EPC STORMWATER REVIEW COMMENTS ARE SHOWN IN ORANGE BOXES WITH BLACK TEXT

2022 Financial Assurance Estimate Form
(with pre-plat construction)

PROJECT INFORMATION		
Peaceful Ridge at Fountain Valley Sub	5/23/2022	EGP-213
Project Name	Date	PCD File No.

ROCK SOCK NTS

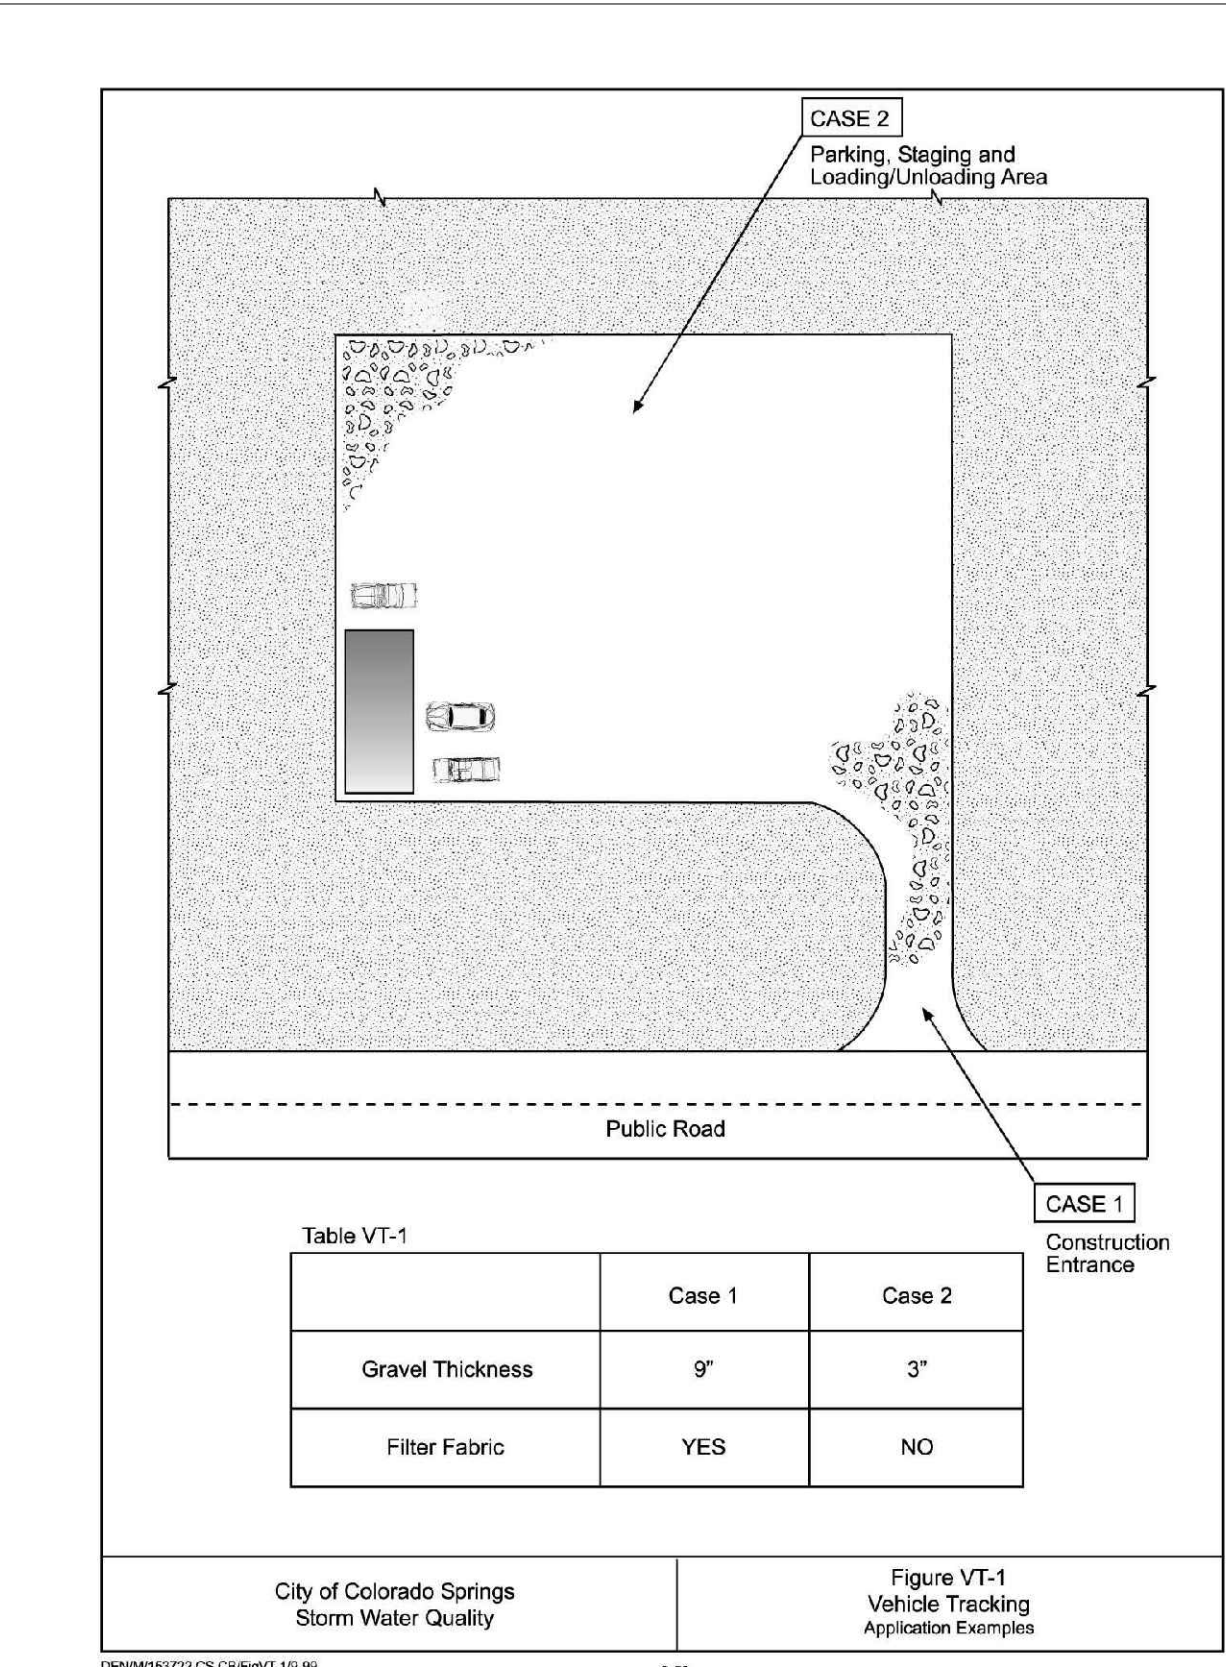
Please include a line item for rock socks. Rock socks were not accounted for with the EGP

CONSTRUCTION DOCUMENTS
 POND DETAILS

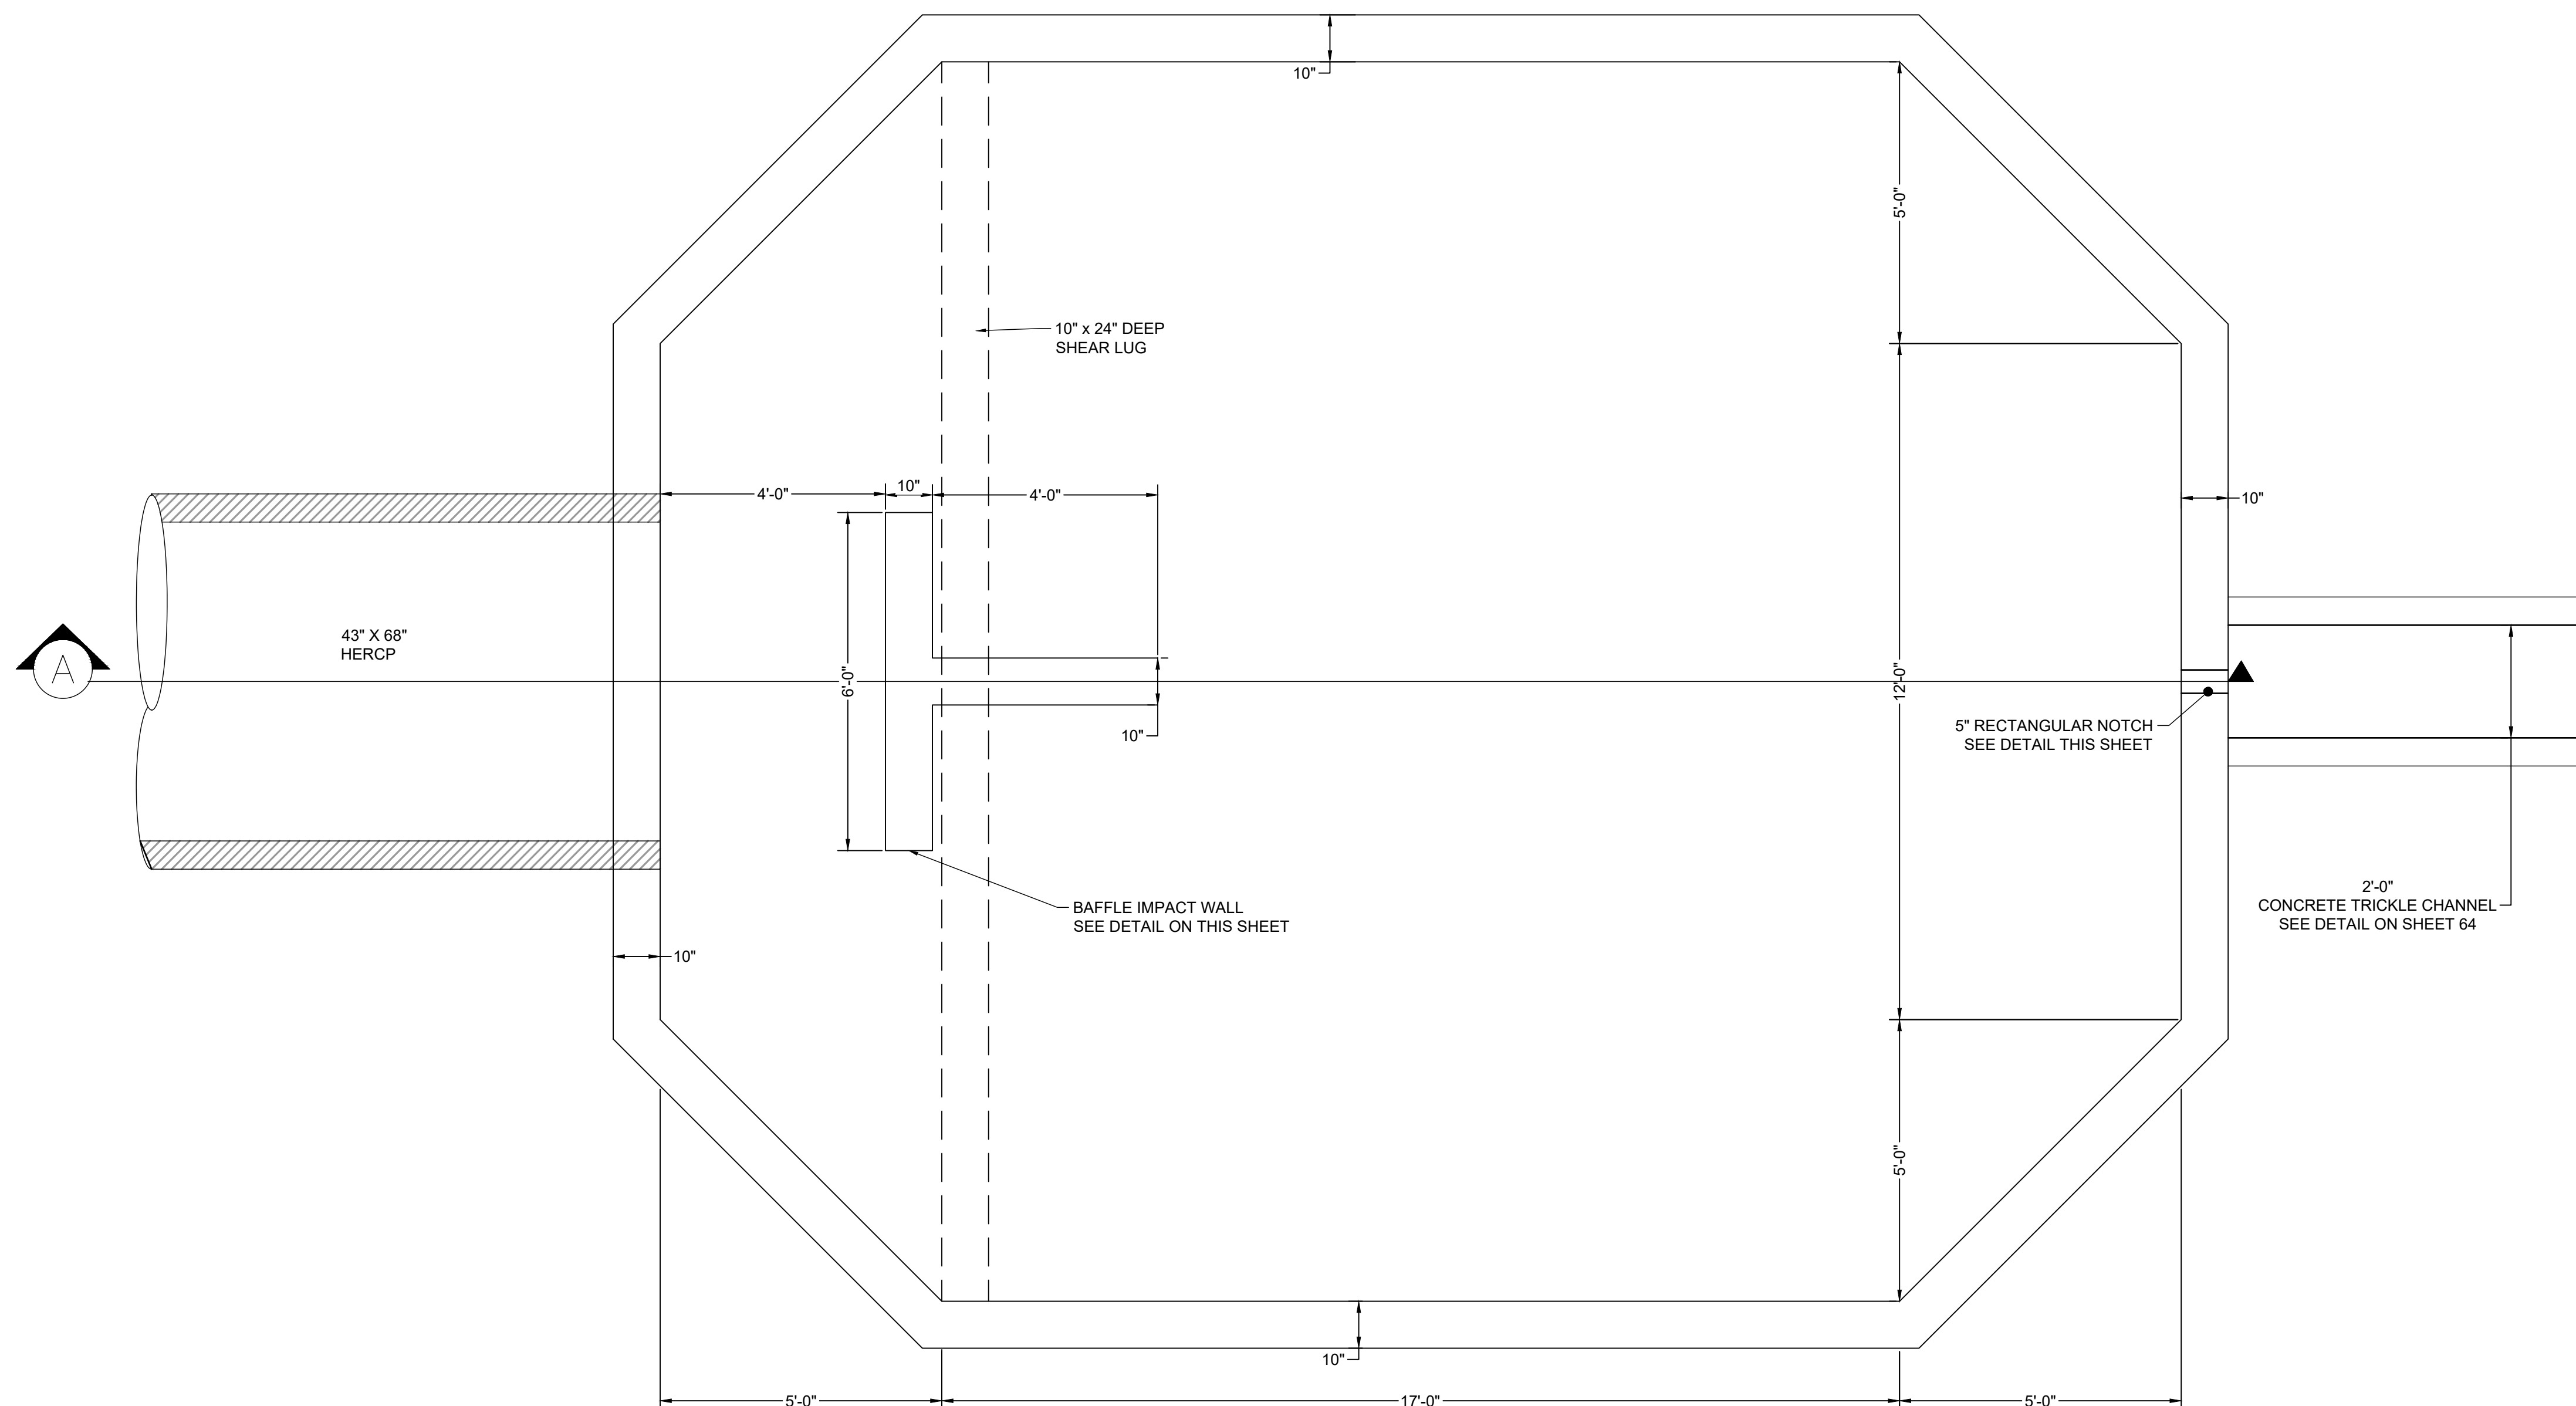
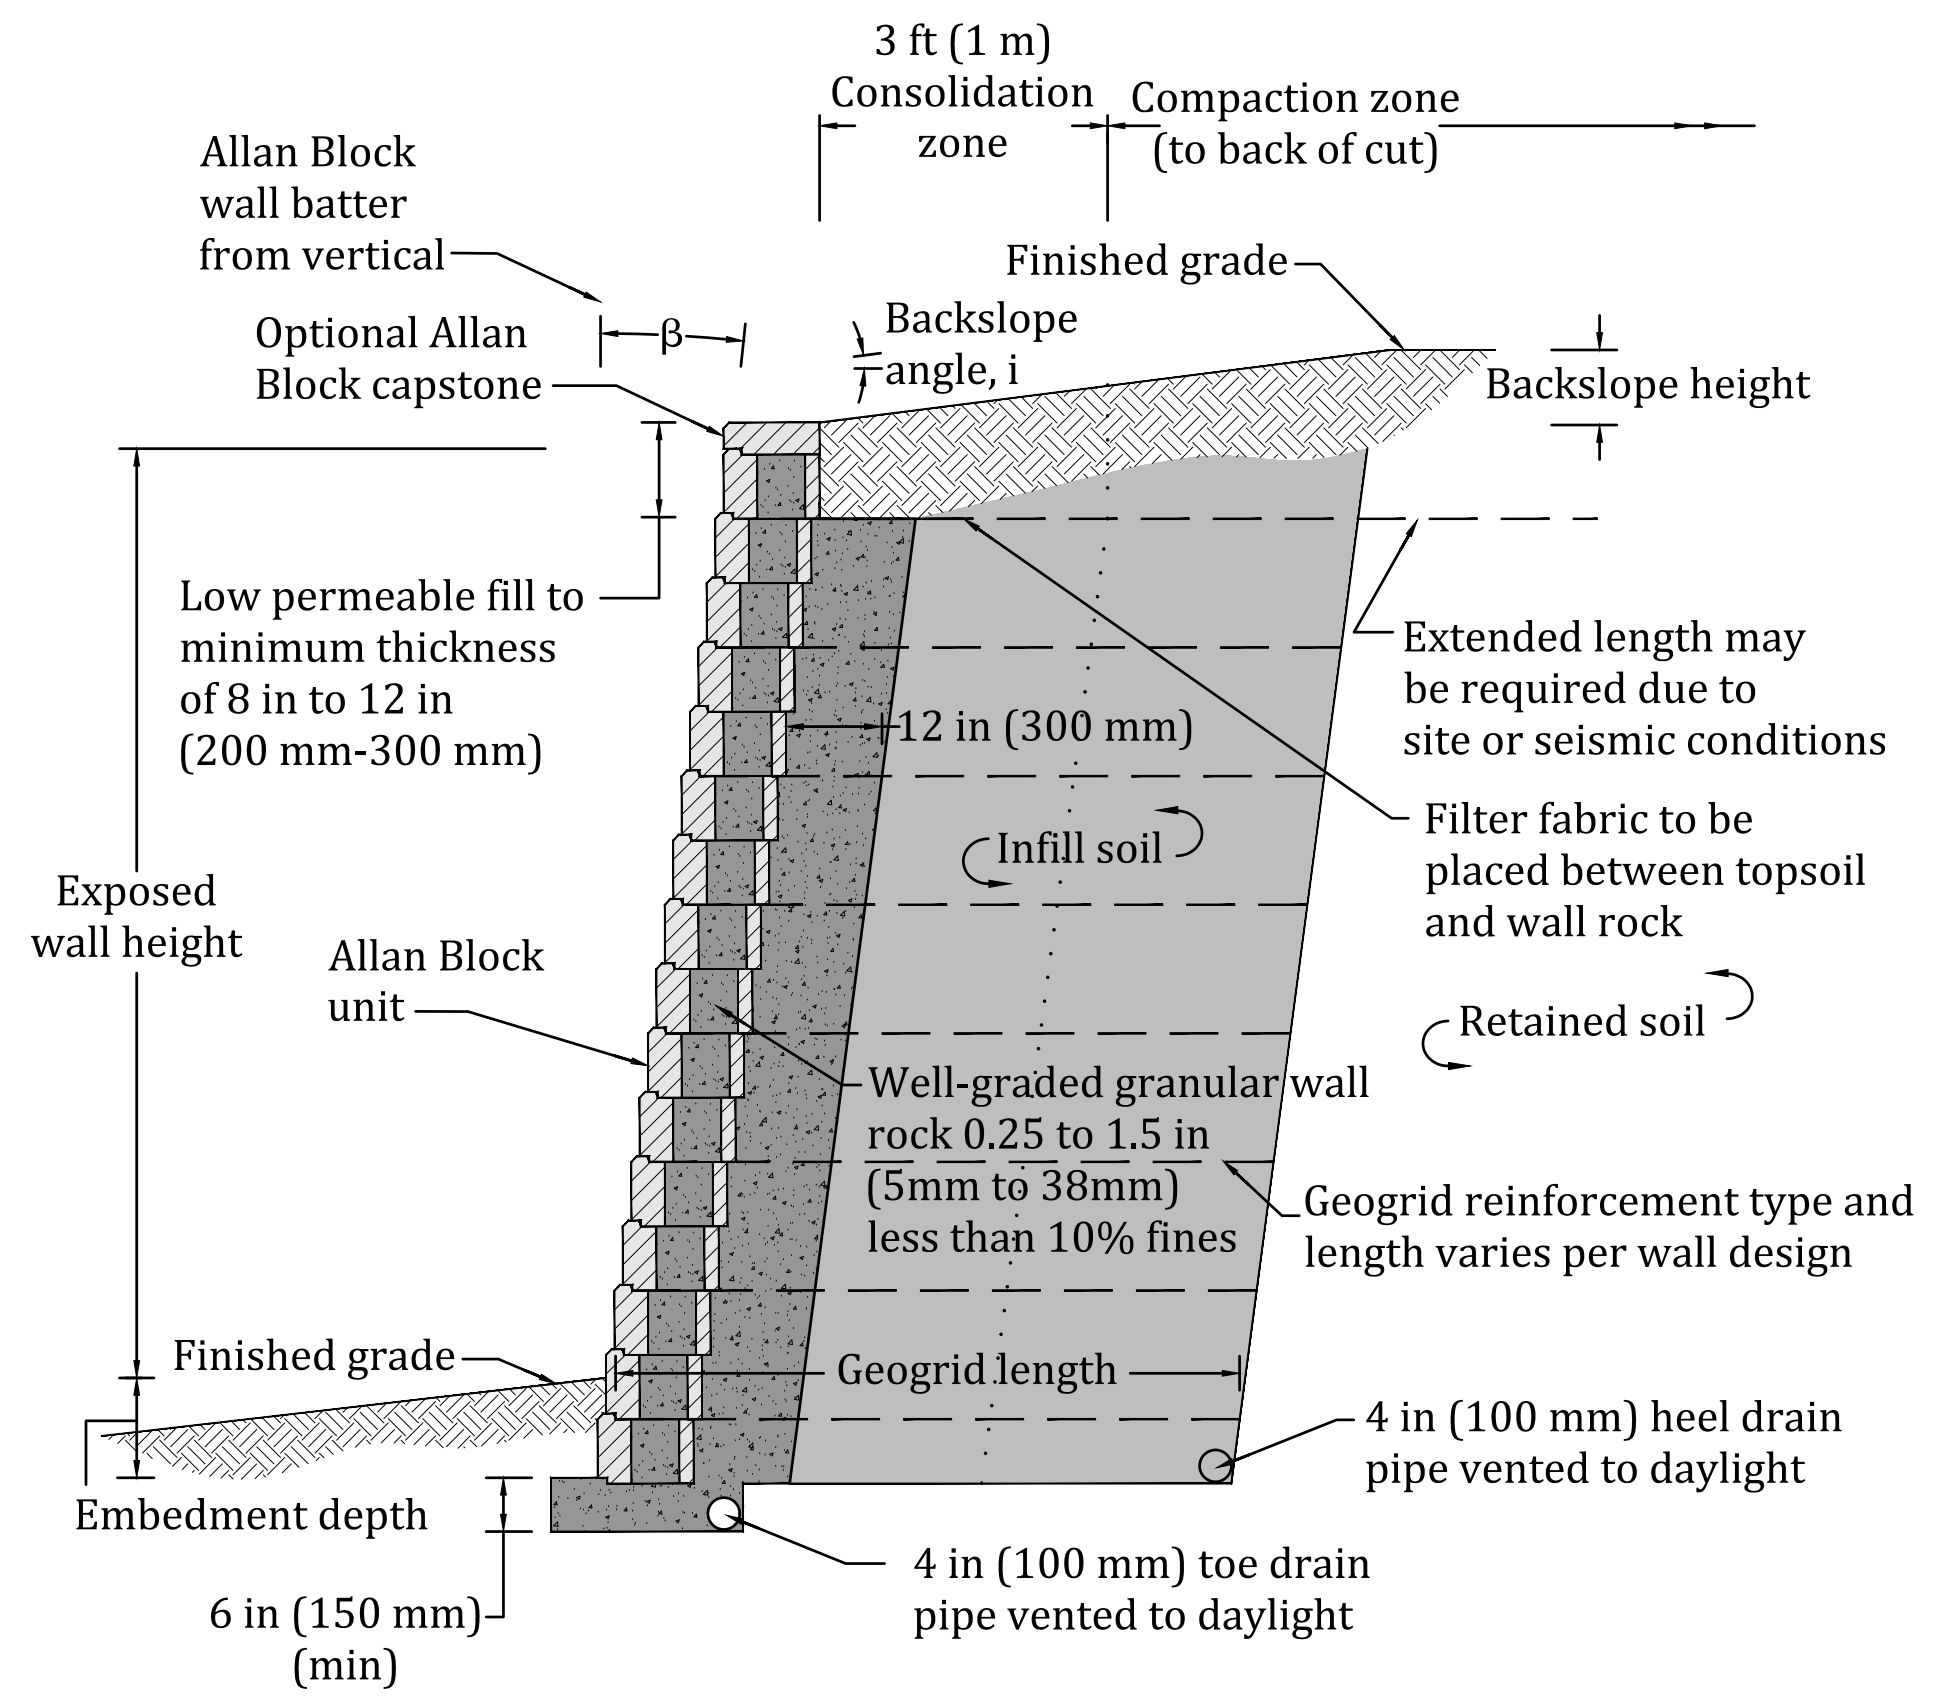
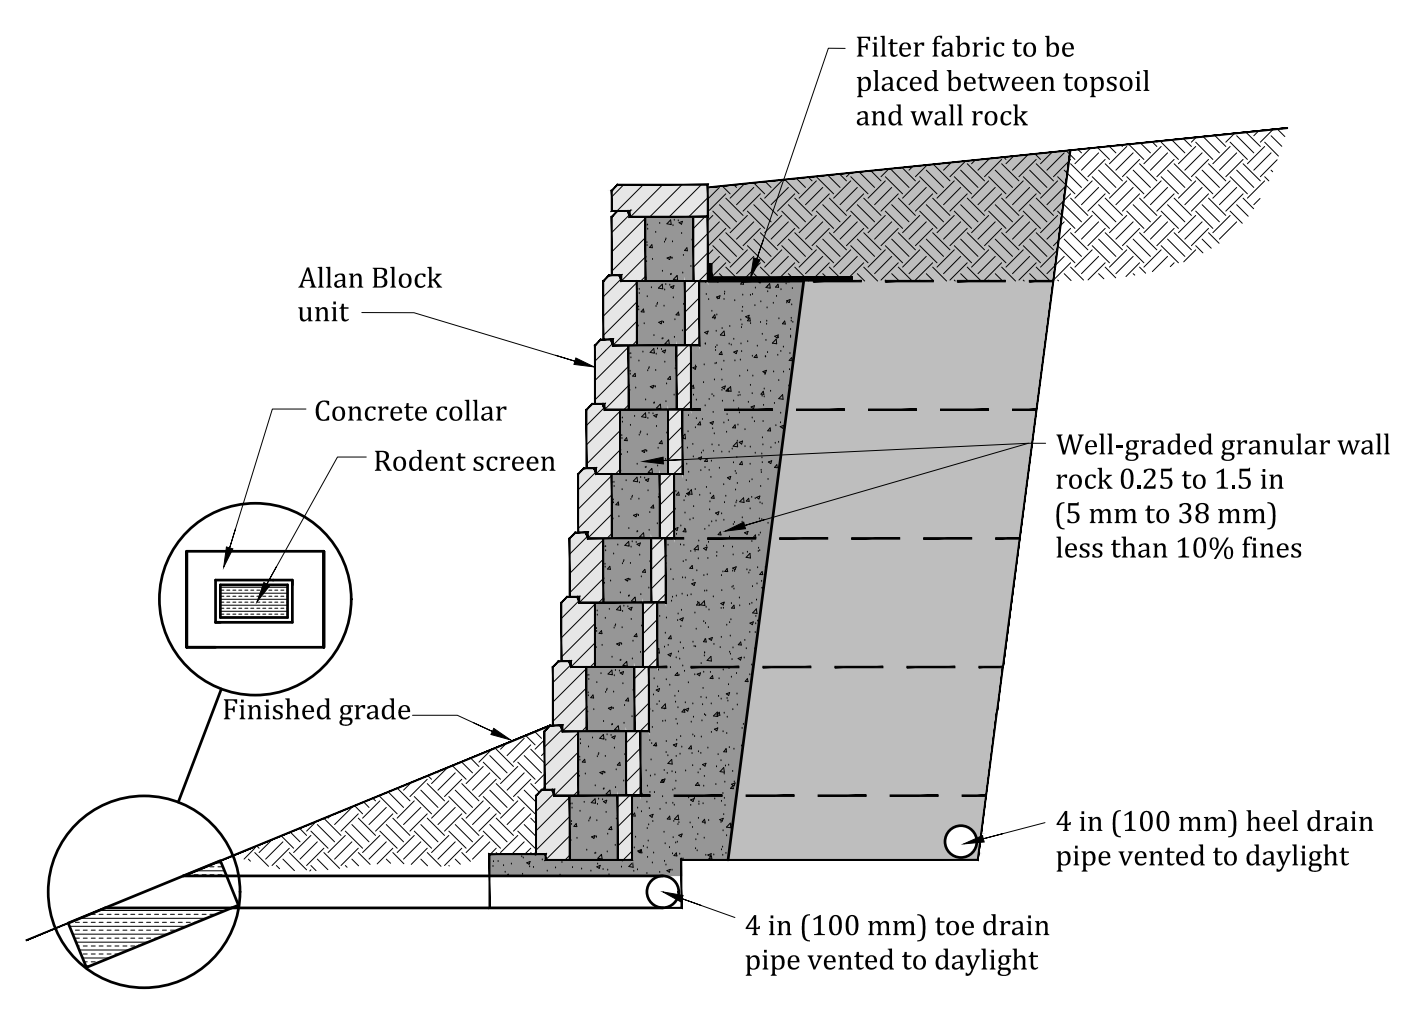
Include retaining walls at/near pond
